**KIRKLEES METROPOLITAN COUNCIL
INVESTMENT & REGENERATION SERVICE**

**DELEGATED DECISION TO DETERMINE APPLICATIONS FOR
CONSENT, AGREEMENT OR APPROVAL REQUIRED BY CONDITION**

Reference No:	2025/44/91011/E
Site Address:	Land Adj, 170, Penistone Road, Shelley, Huddersfield, HD8 8HZ
Description:	Discharge of details reserved by conditions 6 (Bin Presentation Points), 7 (Boundary Treatment Details) and 12 (Phase I Desk Study Report) of previous permission 2023/91272 for erection of detached dwelling
Recommending Officer:	Elenya Jackson

Fencing Section
1 : 50

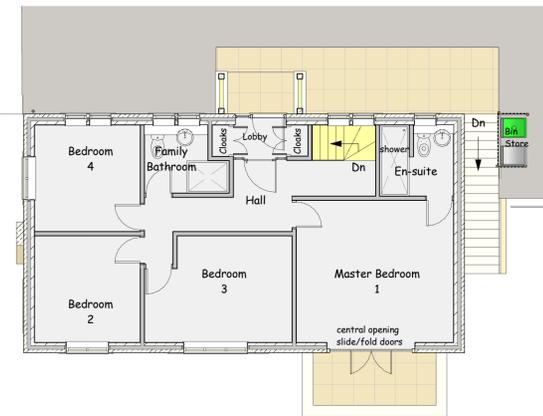
These documents have been reviewed internally. The north of the site would retain its existing boundary treatment, and all other boundaries would be enclosed by a timber boarded fence. The development shall thereafter be completed in accordance with these details before the dwelling is first brought into use and thereafter retained.

The details are considered acceptable for the purpose of condition 7

Bin Collection Point
1 : 50

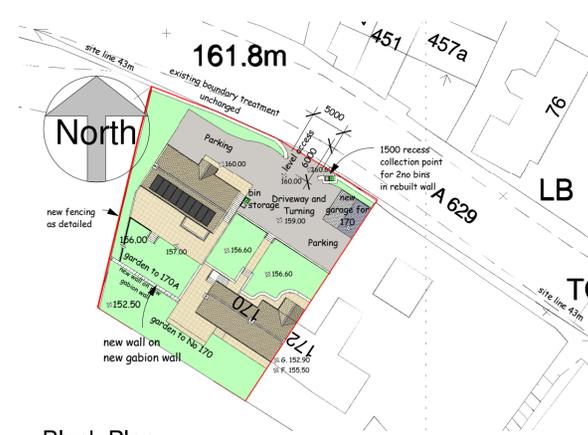
These documents have been reviewed with KC Highways and the proposed bin storage is considered appropriate. The details would satisfy the requirement of condition 6. The approved details shall be provided before first occupation and shall be so retained thereafter.
